# Rezoning Transportation Analysis

Petition Number: 2023-046

## Revision Log:

Date	Description
08-25-23	First Review (NK)
09-20-23	Second Review (NK)
11-22-23	Third Review (TP)
12-20-23	Fourth Review (NK)

PROPOSED STREET DIMENSIONS

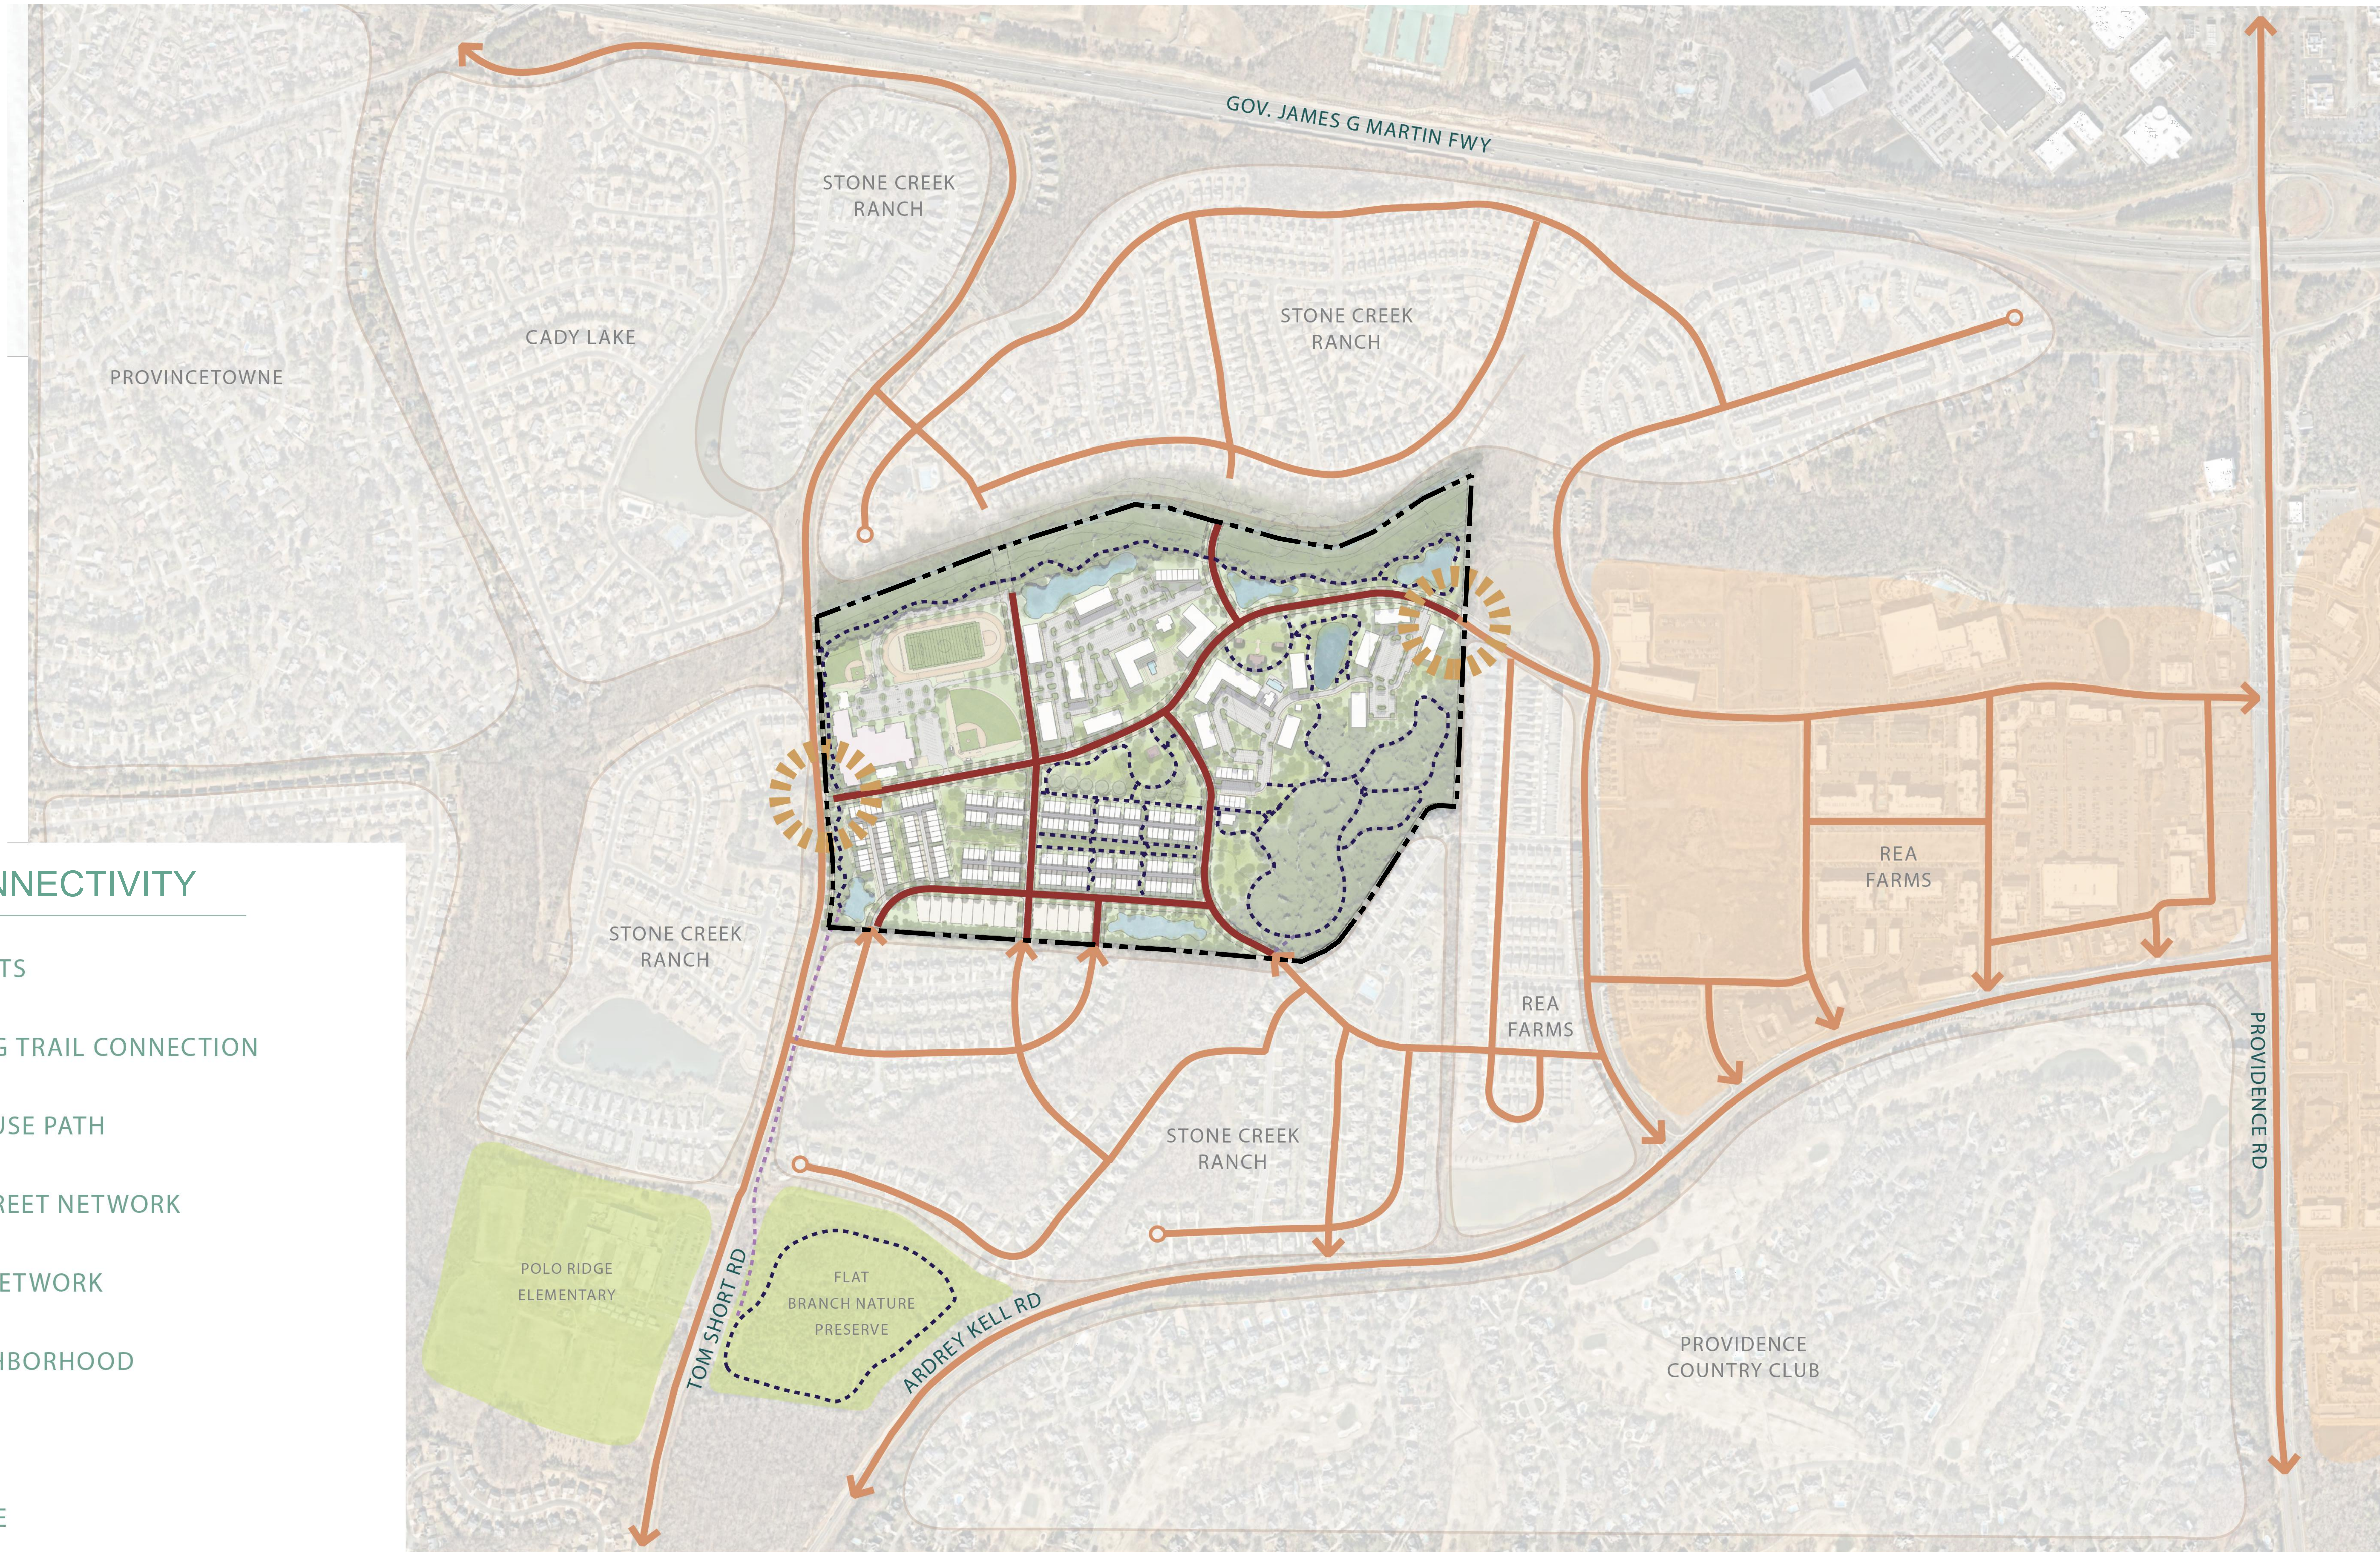
Revise site plan and conditional note(s) to commit to dedicate 46' right of way from the road centerline. The site plan shall label and dimension the right of way from the road centerline.
